**Jordan Springs Public School (SSD-9354)
Request for Additional Information**

Reference is made to the Response to Submissions (RtS) for Jordan Springs Public School (SSD-9354). After careful consideration, the Department is requesting that you provide additional information.

1 ELEVATION - BLOCK C - WEST  
1:100

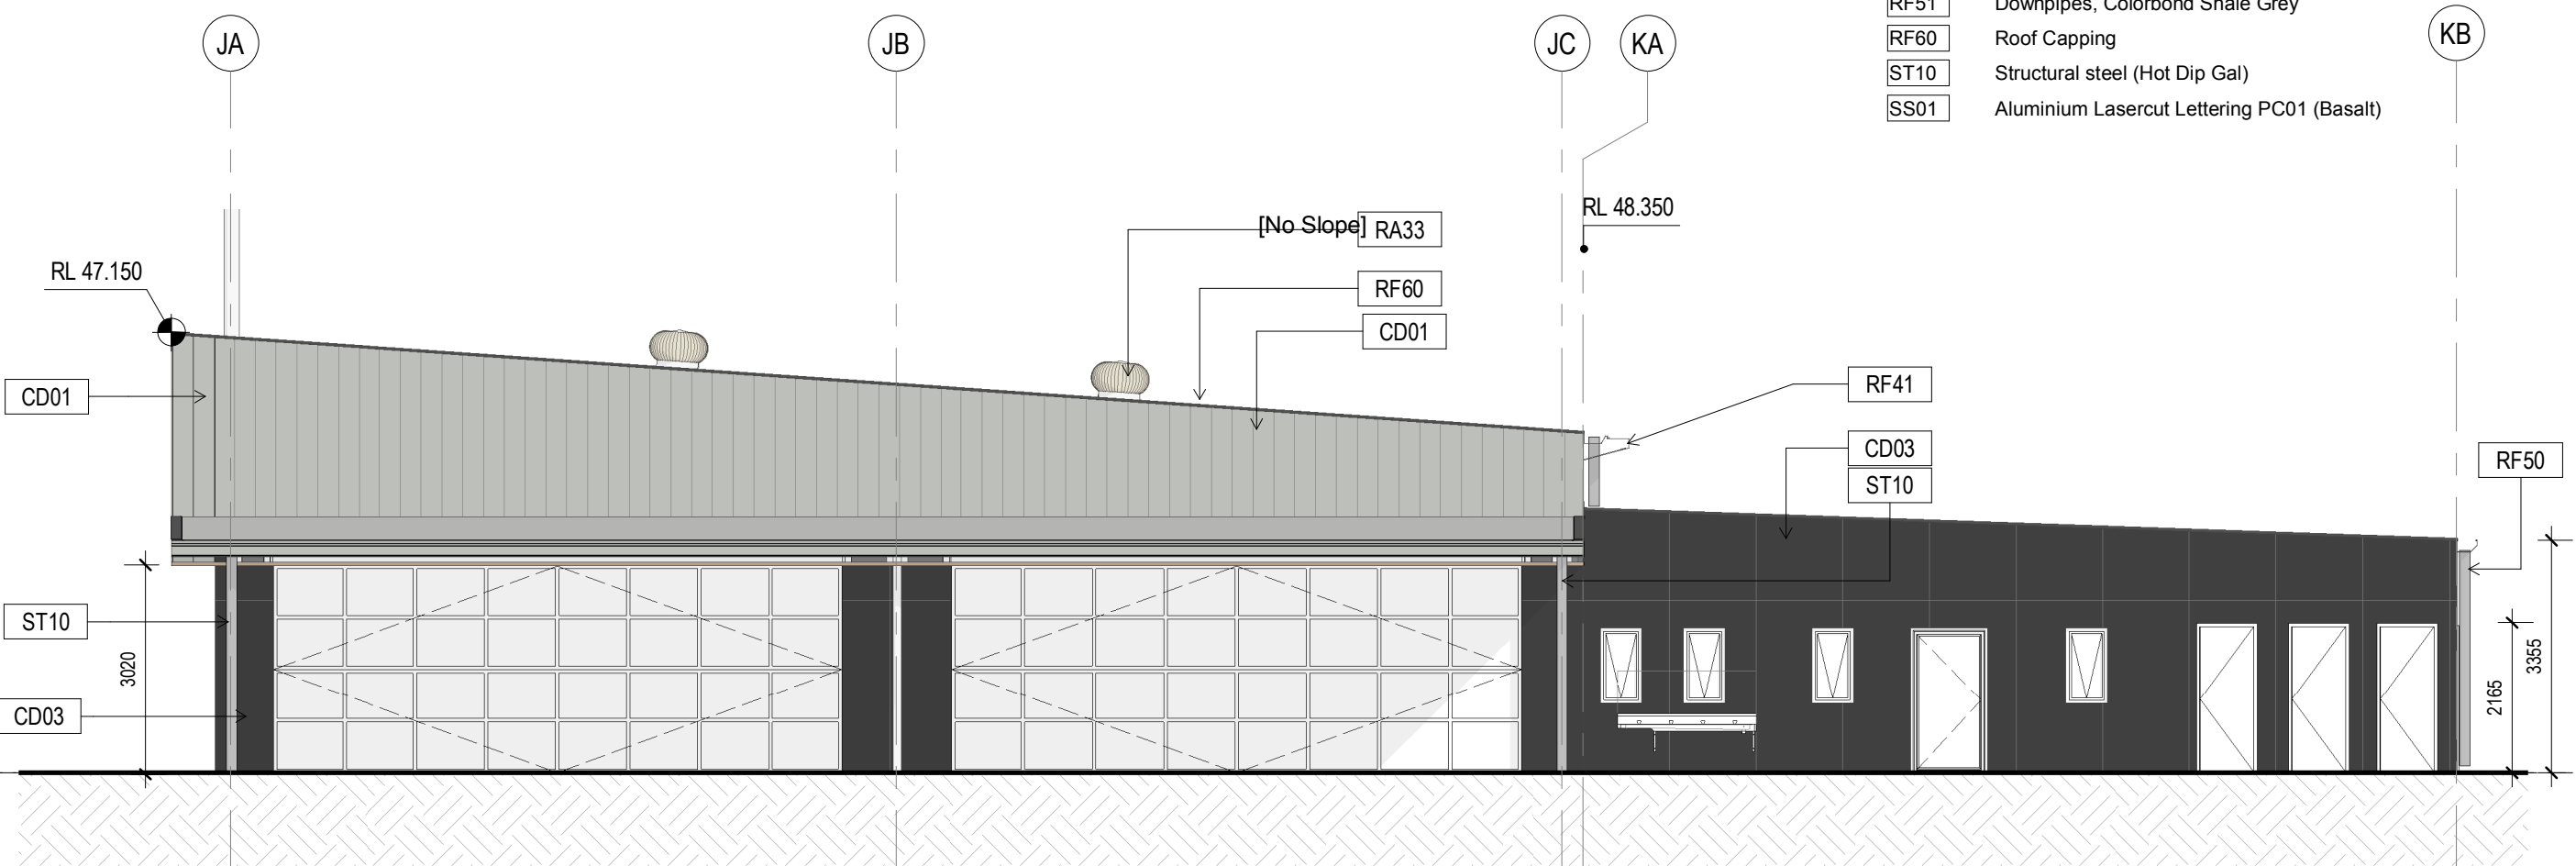
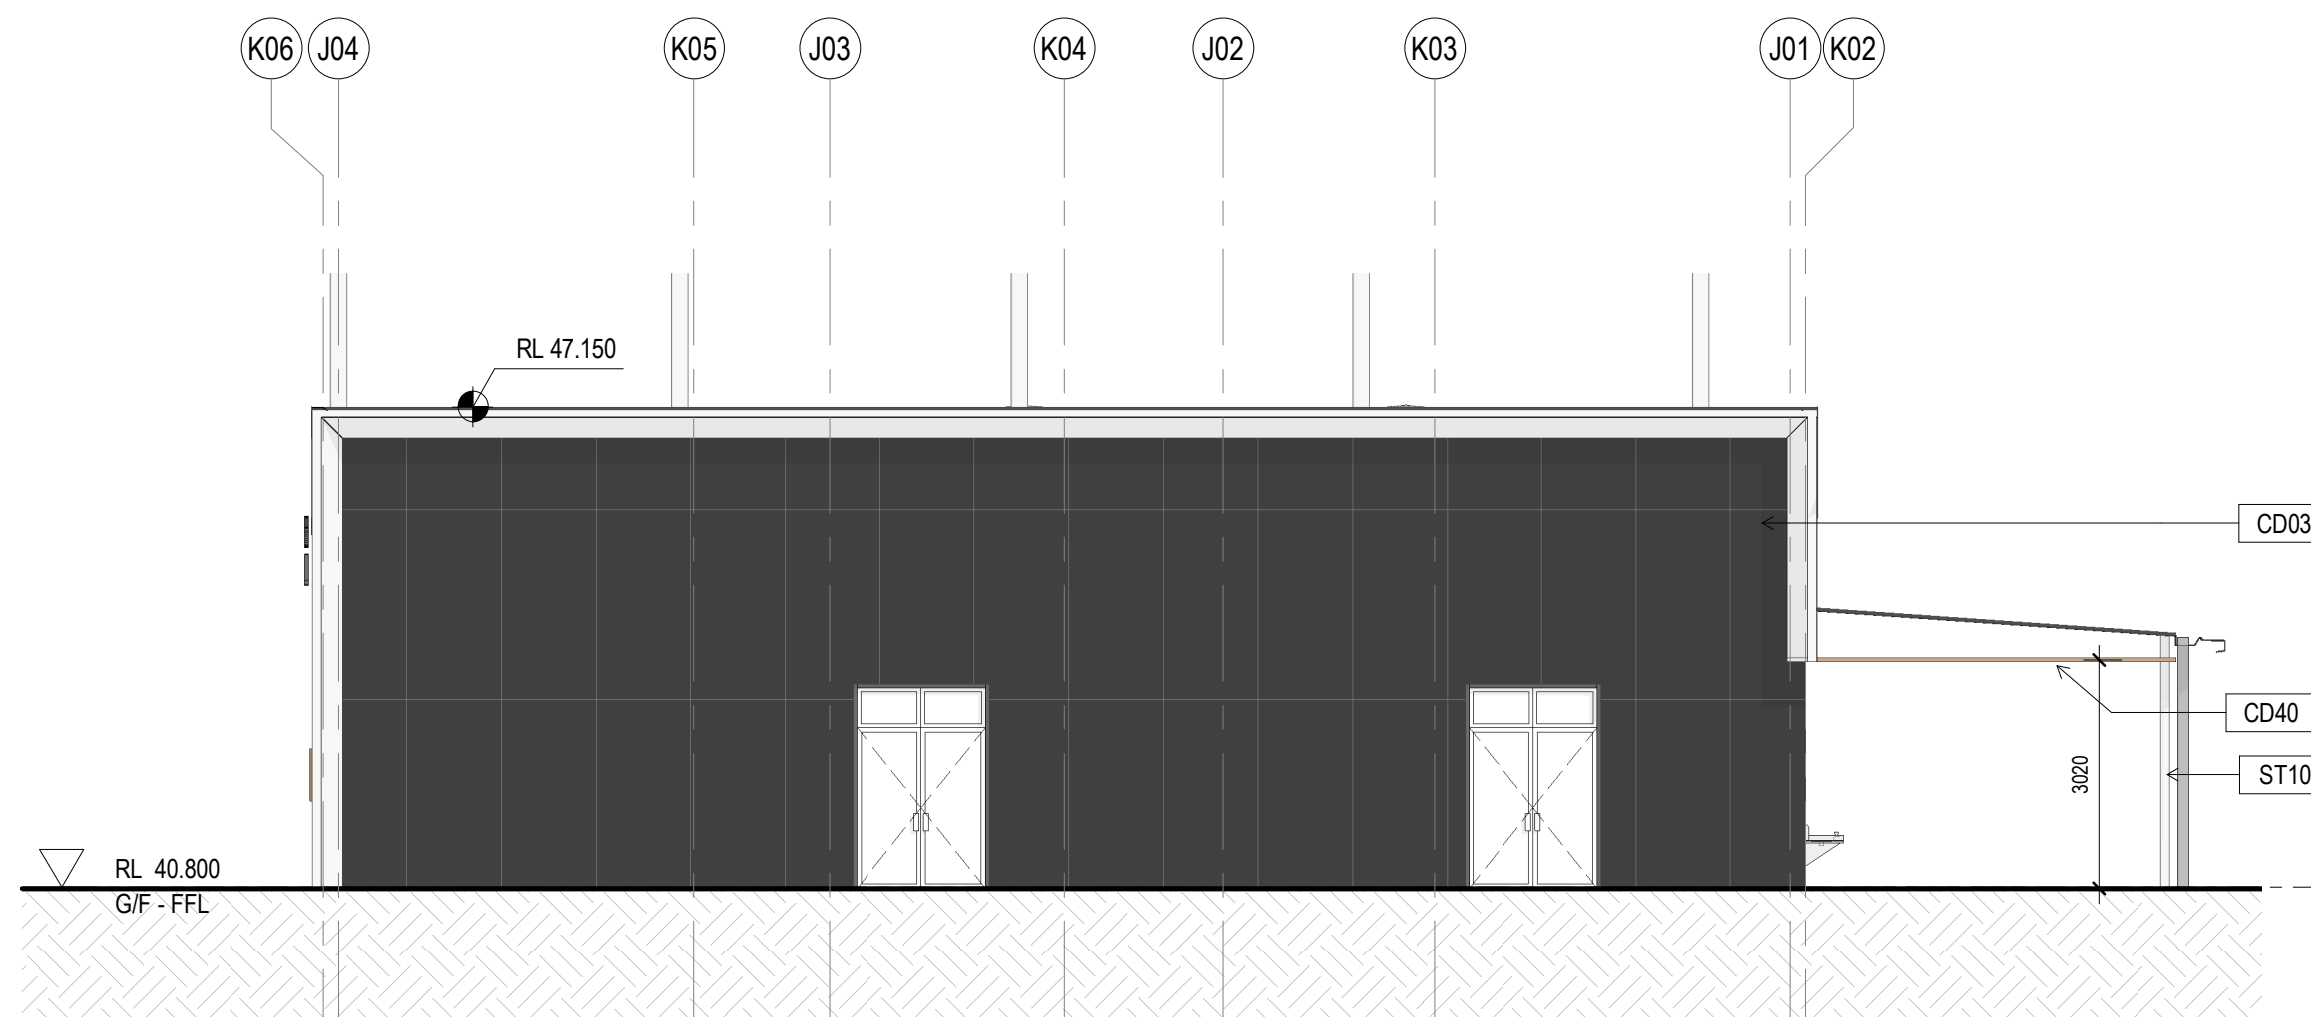
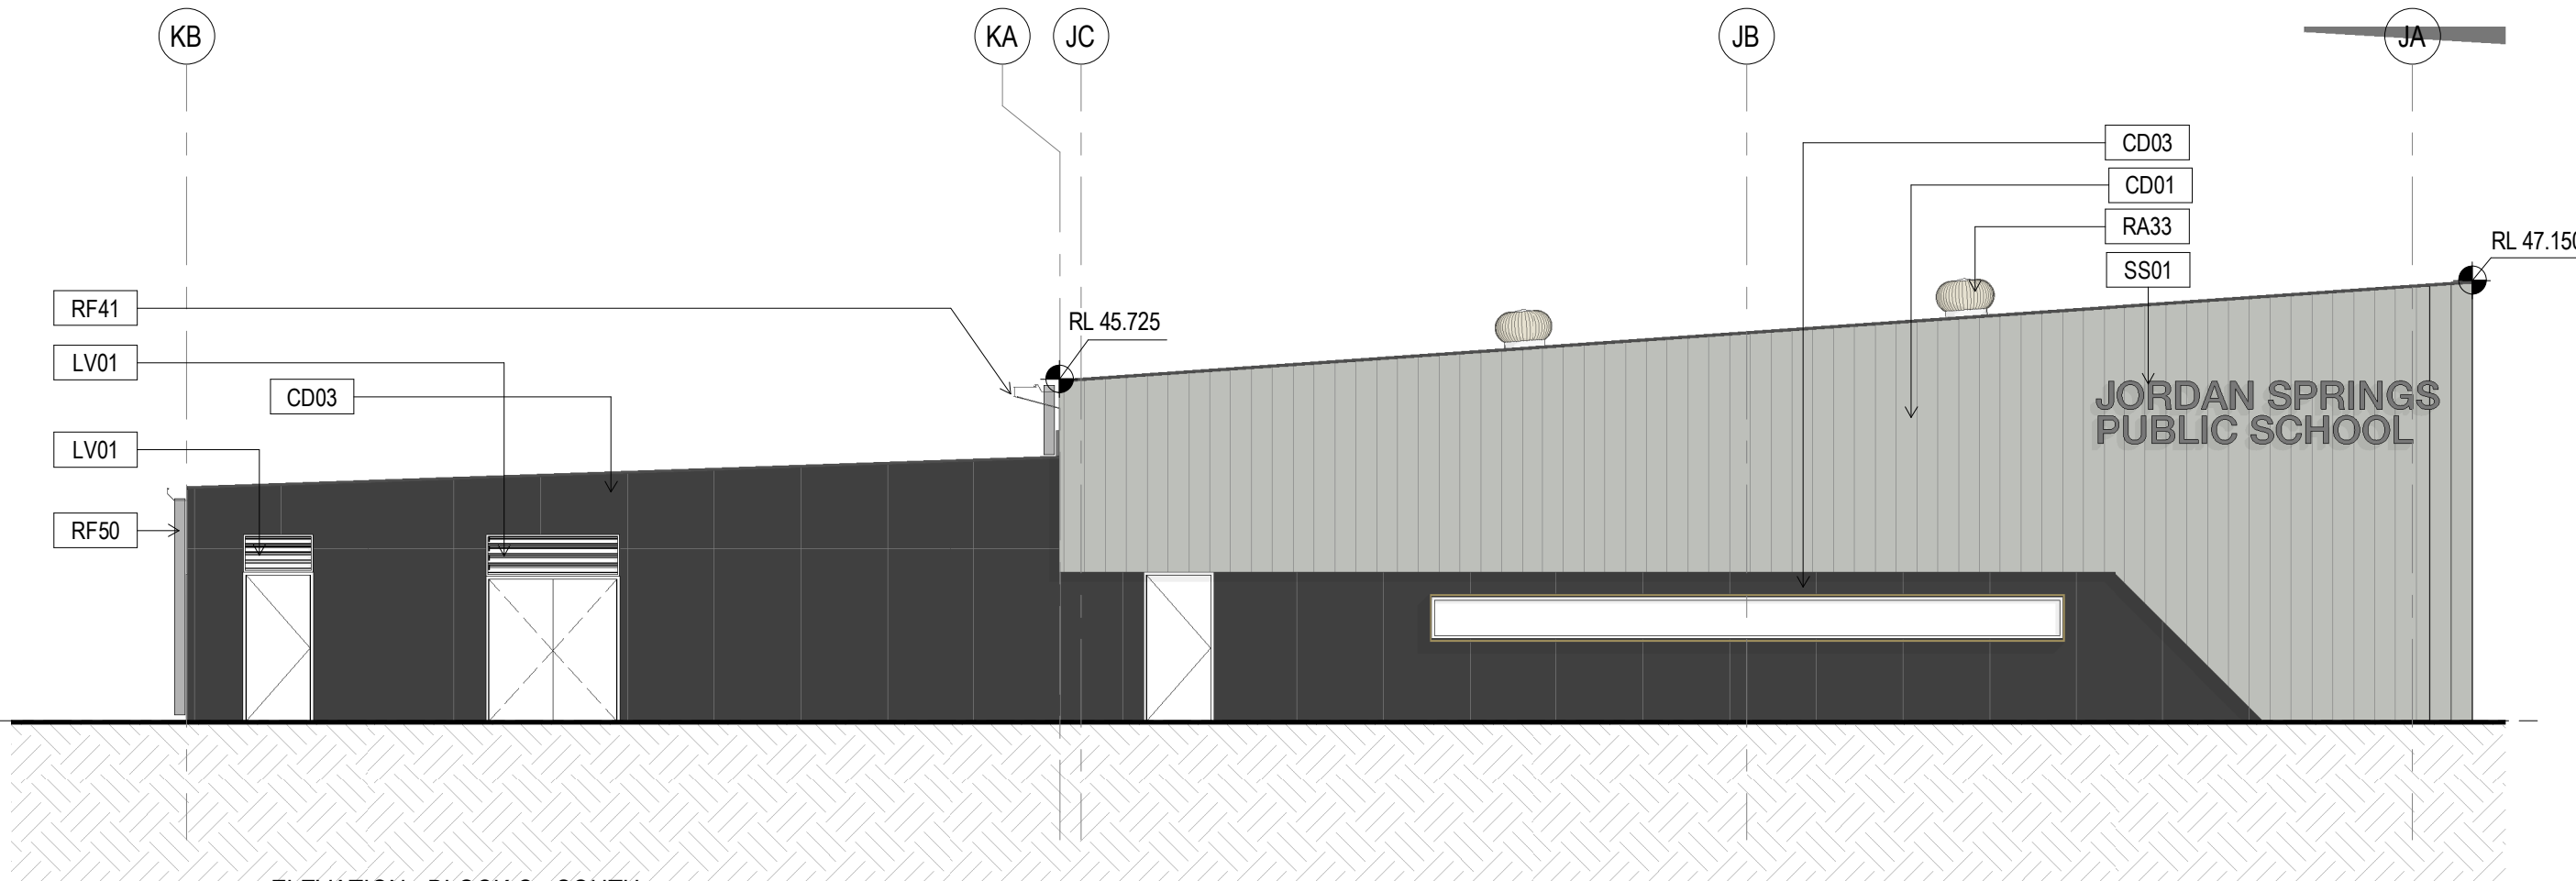
The Department raises concerns with the large, blank facades around the entry and the hall providing a poor interface with the public domain. A redesign to better address the street frontage is required.
